Fire Marshal Division

RE: Britton Welding
425 Royal Pines Lane
Lillington, NC 27546

Application Number BCOM1909-0001

Life Safety Plan

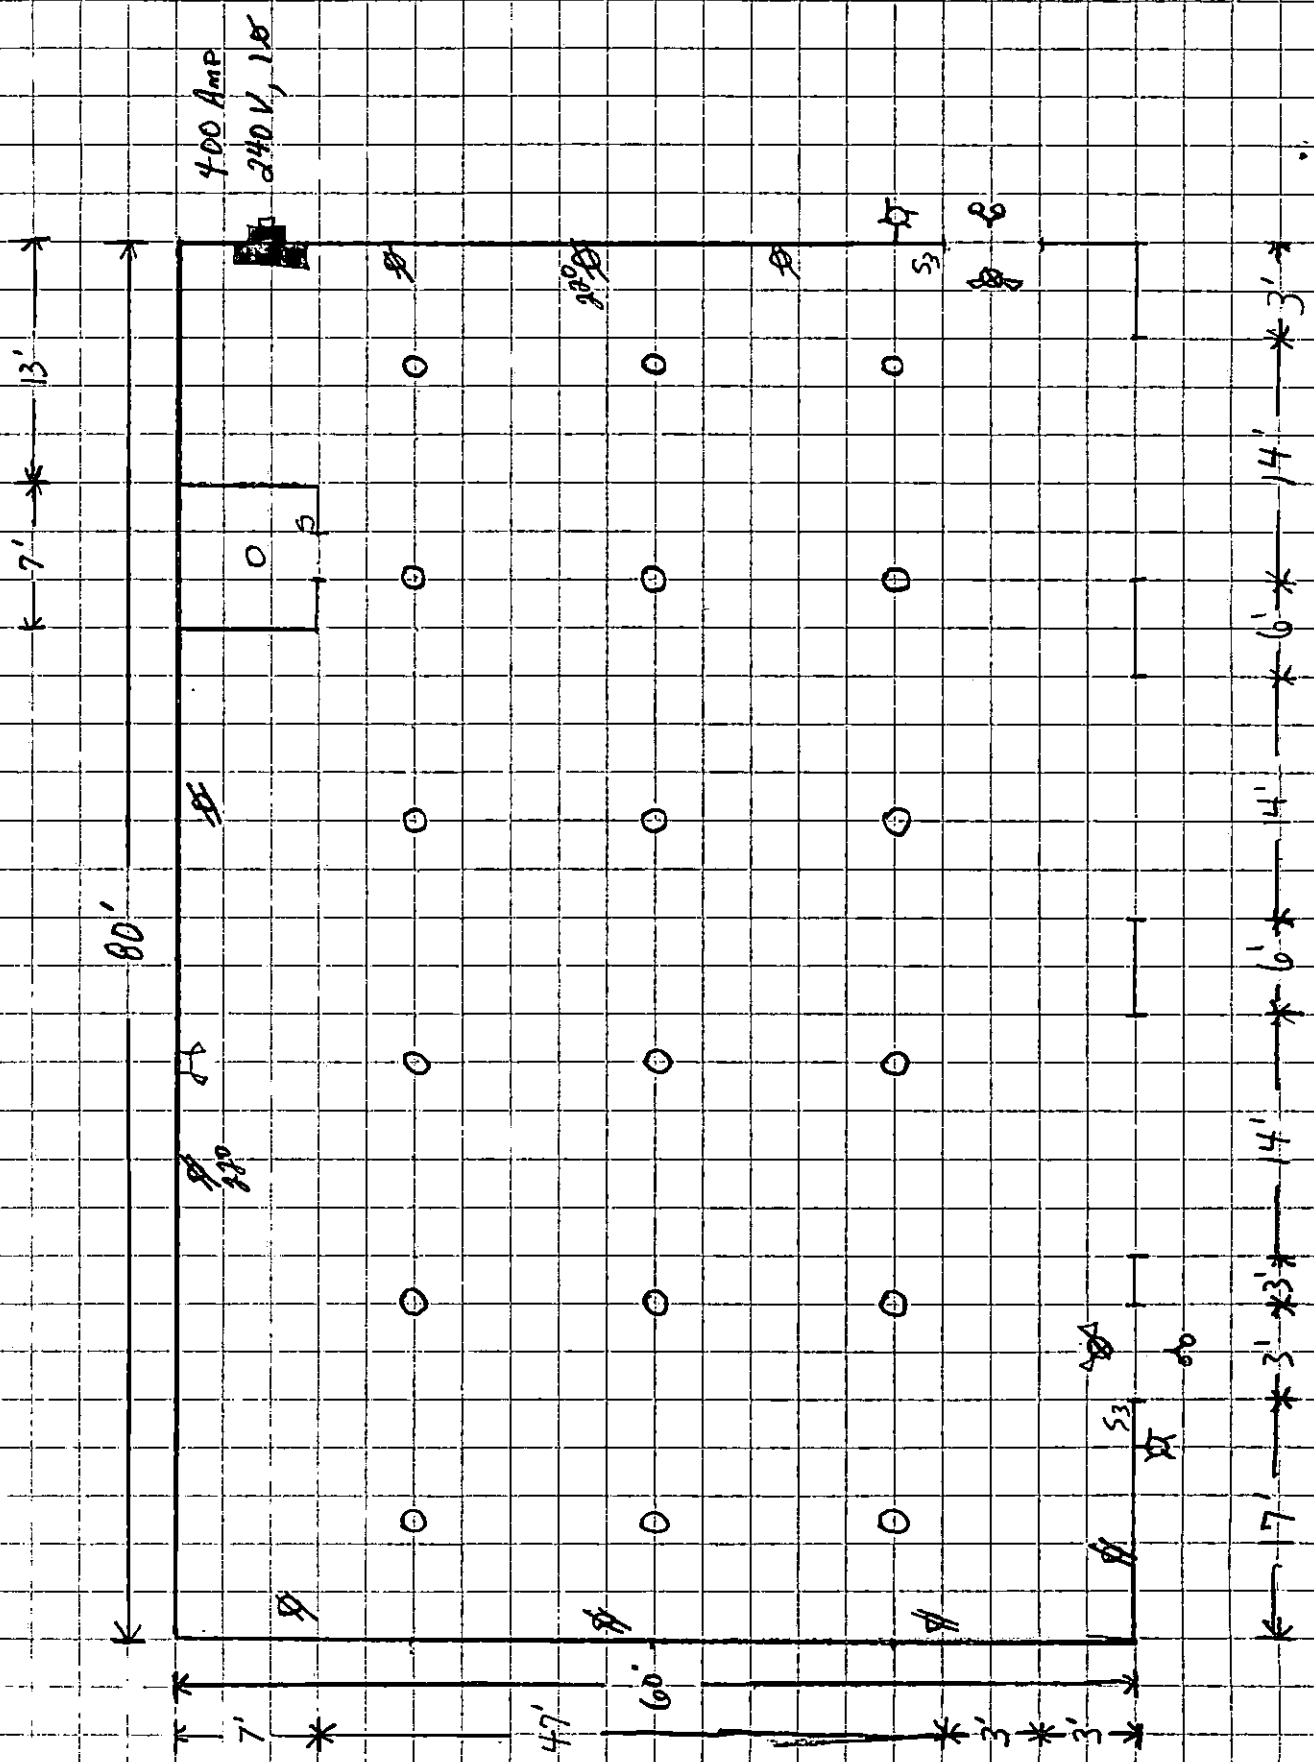
- **906.1 Fire Extinguishers**
 - Fire extinguishers shall be placed in approved locations as drawn on the approved plans.
 - The fire extinguishers provided shall have a minimum rating of 2A 10B: C and shall not be installed higher than 5 feet above the finished floor.

- **1006.1 Emergency Lighting**
 - The means of egress, including the exit discharge, shall be illuminated at all time the building space is served by the means of egress is occupied.
 - Means of egress consist of three separate and distinct parts: the exit access, the exit and the exit discharge.
 - Please provide emergency lighting in any interior rooms.
 - The means of egress illumination shall not be less than 1 foot-candle at
